Application no: **3/2021/1090**

Address: **43 St Marys Gardens Mellor BB2 7JW**

Proposal: **Proposed first floor side extension and single storey rear extension.**

The Local Highway Authority have viewed the plans and highway related documents and have the following comments to make:

Drawing Title
**EXISTING PLANS
+ ELEVATIONS**

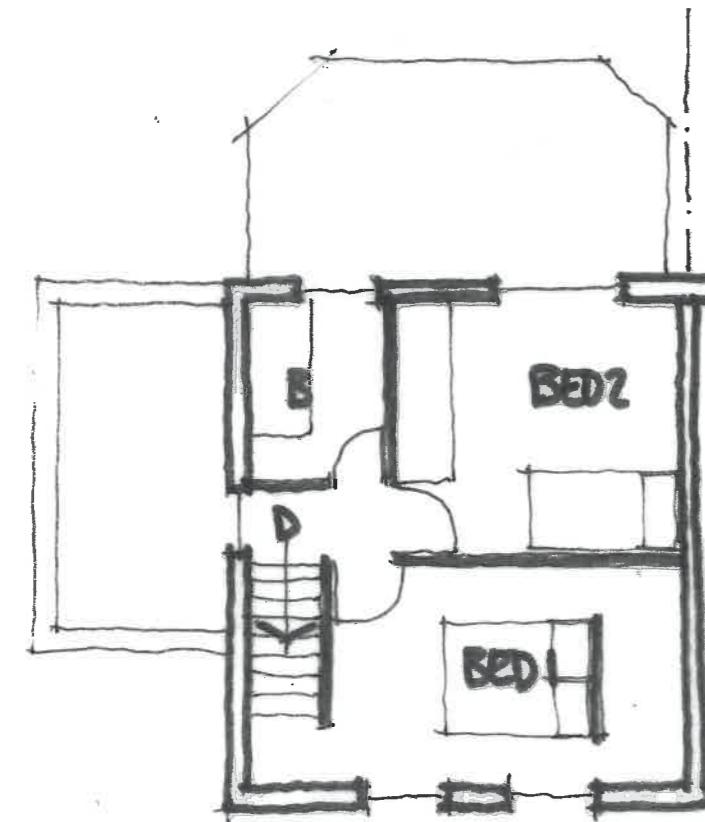
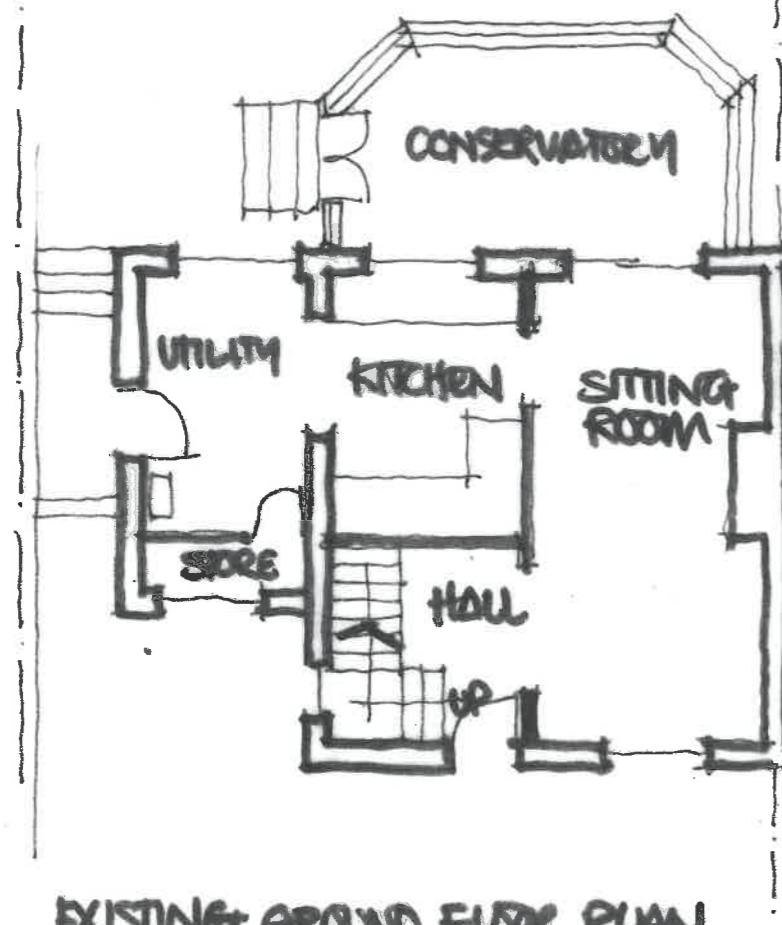
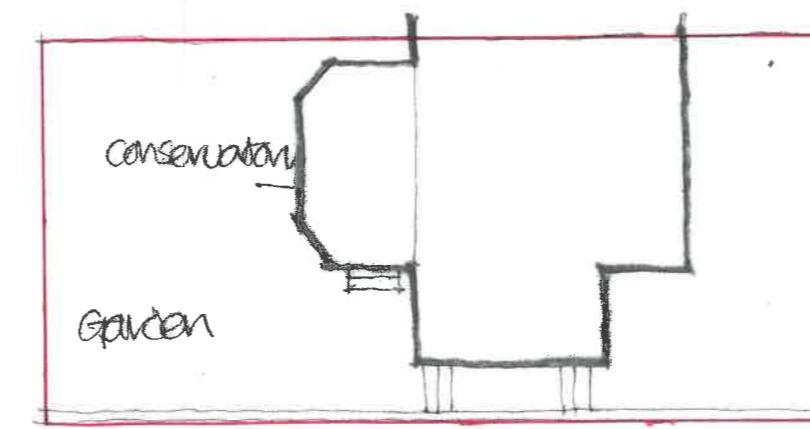
The LHA have reviewed SPA drawing number 01A titled "Existing Plans and Elevations" and understands that the existing dwelling is a 3-bed property.

Client	MR. J. SIMPSON		
Job Title	PROPOSED ALTERATIONS 43 ST MARYS GARDENS MELLOR BB2 7JN		
Drawing Title			
PROPOSED PLANS + ELEVATIONS			
Scale	1:100 CAD	Date	SEPT 21
Drawn	DNI

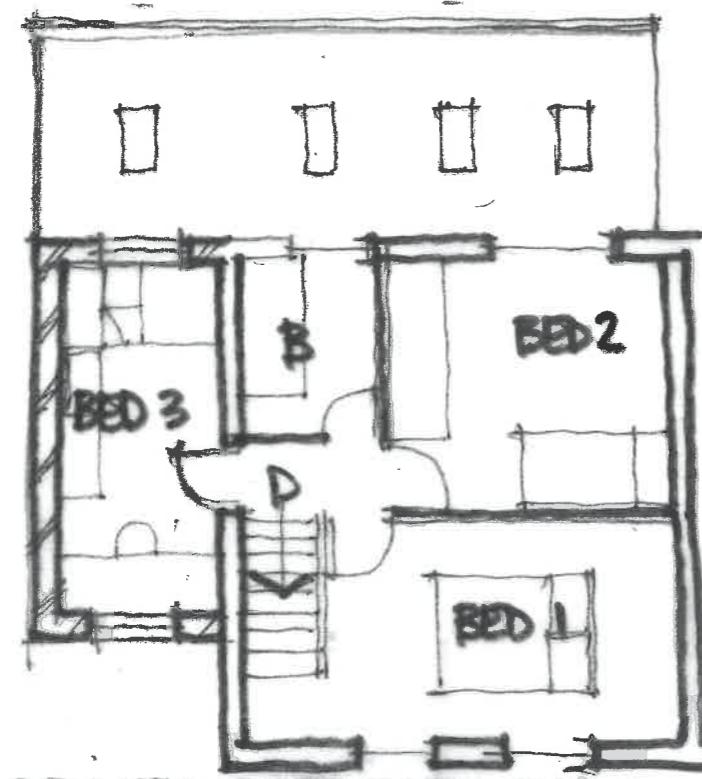
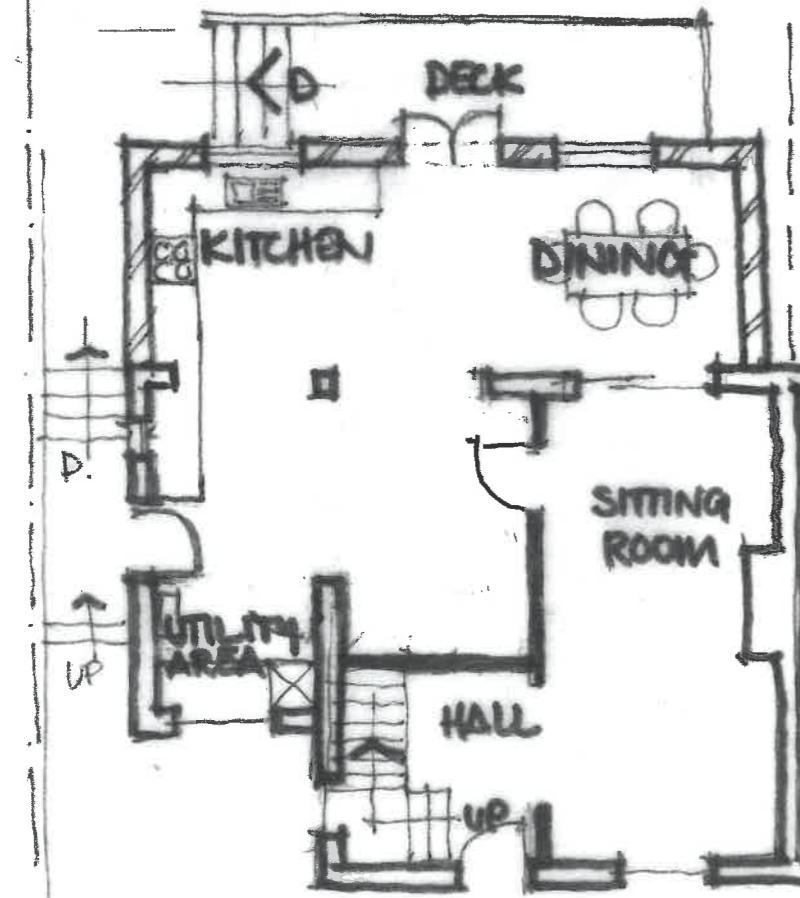
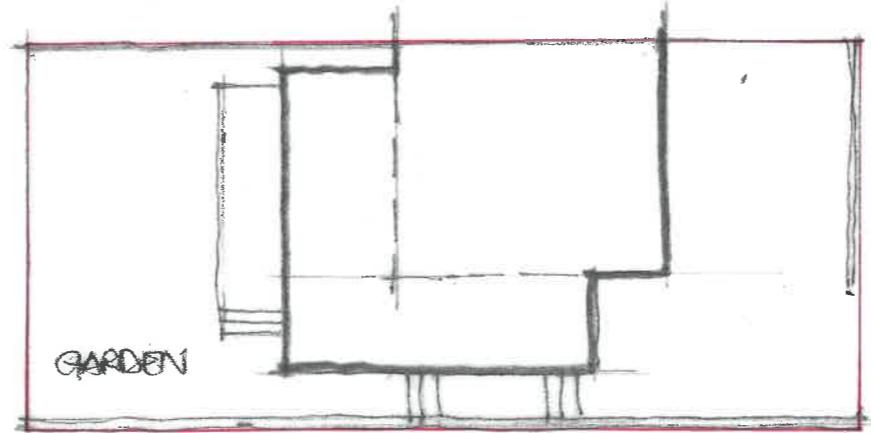
Following the proposal, as shown on SPA drawing number 02A titled "Proposed Plans and Elevations," the dwelling will become a 4-bed property.

For the site to comply with the parking guidance as found in the Joint Lancashire Structure Plan, the LHA require the site to provide 3 car parking spaces.

However, the dwelling is only able to provide 2 car parking spaces with them both being located on the existing driveway. Therefore, there is a shortfall in one car parking space.

Notwithstanding this the LHA will accept the shortfall in one space at the dwelling. This is because whilst this is not ideal the LHA would not advise refusal of an application based on a shortfall of one parking space, given the existing situation on-street and so the LHA have no objection to the proposal.
